RE: Enquiry about planning permission-26 Cordingley Road, HA47HQ

RE: Enquiry about planning permission-26 Cordingley Road, HA47HQ

### Window in Closed State

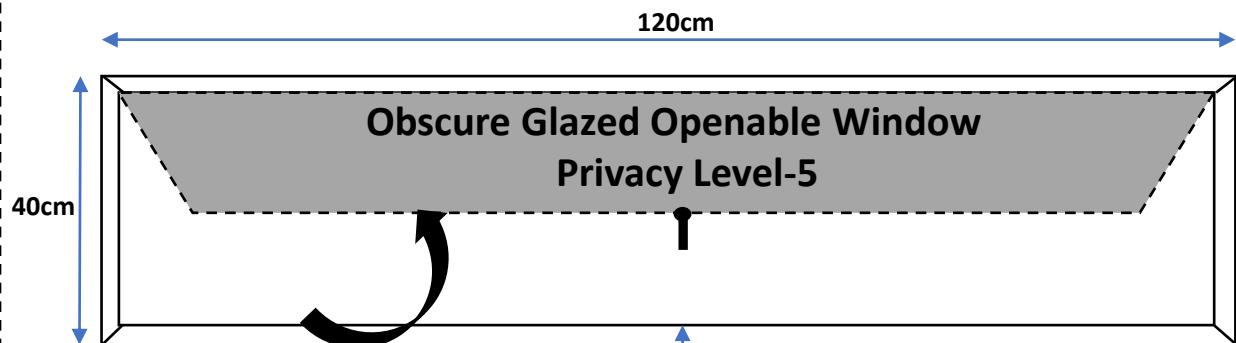
- 1) **Scenario-1:** If we plan to install an obscure glazed "openable" side window at the level of the first floor in the staircase in the end of terrace wall (which I believe is called as side elevation) and if it is 1.7 meters "above" the stair immediately below the centre part of the opening of window (as referred in the attached picture to this email). Does this require planning permission?
- 2) **Scenario-2:** The same as scenario-1, except if we plan to install an obscure glazed "non-openable" side window, does this require planning permission?

The sketch provided would be permitted development: i.e. scenario 1-

Scenario 2 would not require planning permission either.
